Ref: 2020/60/92331/E- Land east of, Leeds Road, Chidswell, Shaw Cross, Dewsbury

Ref: 2020/60/92350/E-Land south of, Heybeck Lane, Chidswell, Shaw Cross, Dewsbury

We note that applications 2020/60/92331/E (Chidswell) and 2020/60/92350/E (Heybeck) are closely linked and cover the same site allocation/masterplan site and as such, share many of their ecological reports. As such please take the below comments as applying to both applications due to the significant potential in combination effects and closely linked design.

Figure 4 Post-development habitats.

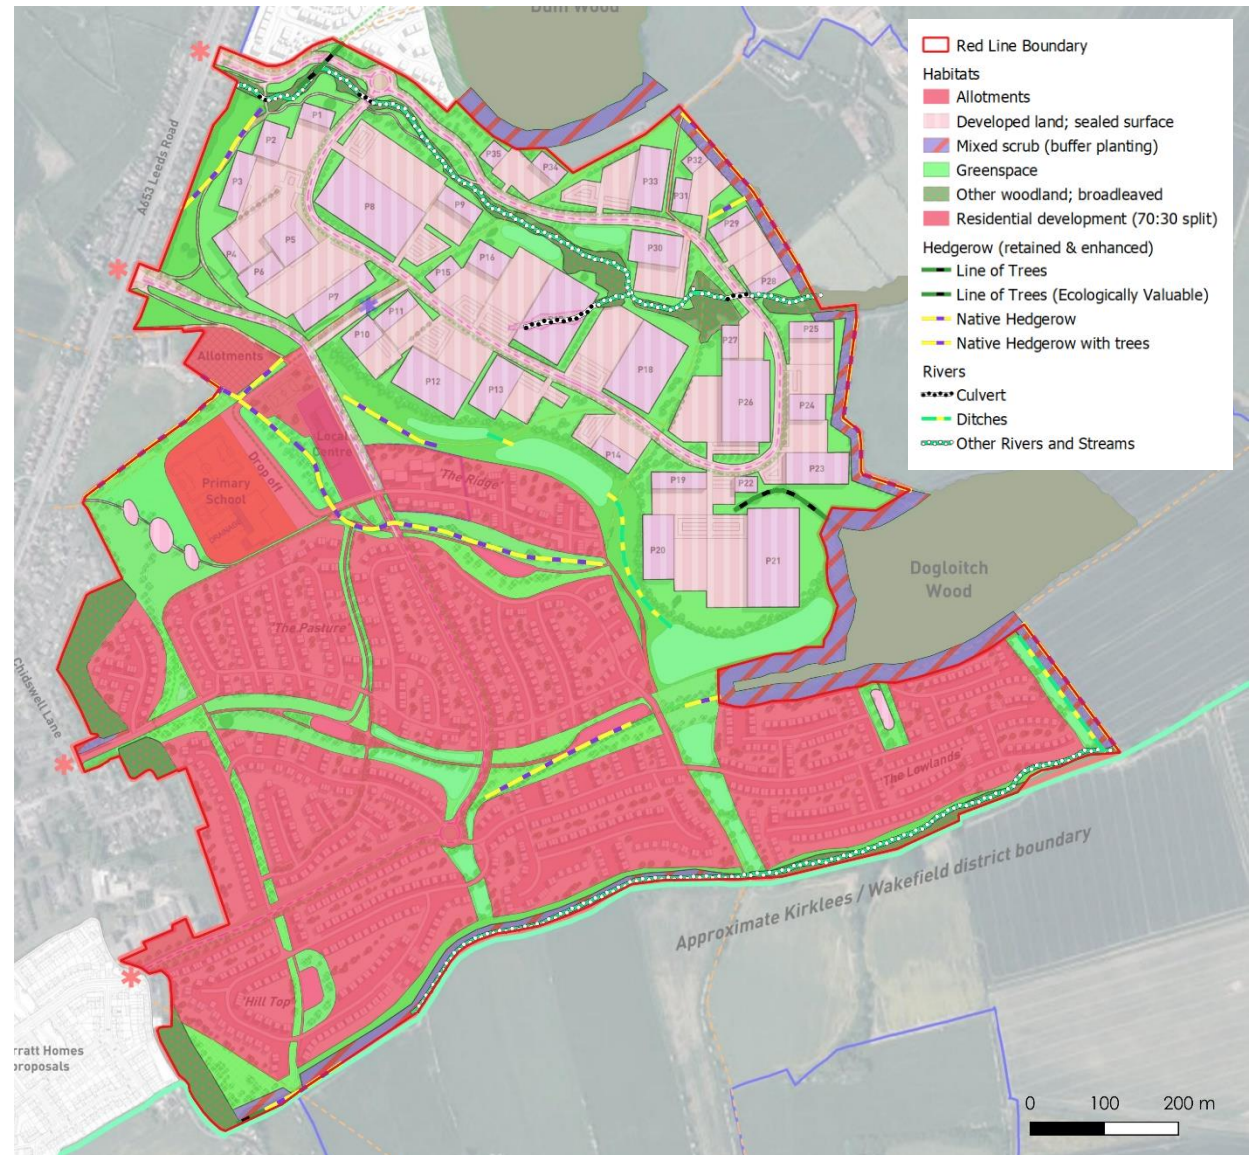
We have concerns over off-site compensation areas proposed on the two sites of ancient woodland, Dogloitch and Dum Woods. Areas of priority habitat (such as ancient woodland) can be used for off-site BNG, however, an important consideration is that the proposed uplifts must be a quantitative gain upon the existing baseline condition of the habitat. We note that throughout the documentation supporting both applications, there is reference to both Dogloitch and Dum Woods, being excluded from the BNG Assessments:

“Dum Wood & Dogloitch Wood have not been considered within this assessment but ultimately will be managed to increase their condition score and minimize the impacts of increased recreational pressure.”

In the first instance, without the baseline conditions assessed, there is inadequate information presented indicating how the 10% BNG uplift will be achieved on these ancient woodland sites.

We have concerns over the lack of an Ancient Woodland Management Plan for the two sites of ancient woodland, Dogloitch and Dum Woods. The High-Level Biodiversity Net Gain Assessment supporting the original application, included the following statement:

“Dum Wood & Dogloitch Wood have not been considered within this assessment but ultimately will be managed to increase their condition score and minimize the impacts of increased recreational pressure. This will likely generate additional units.”
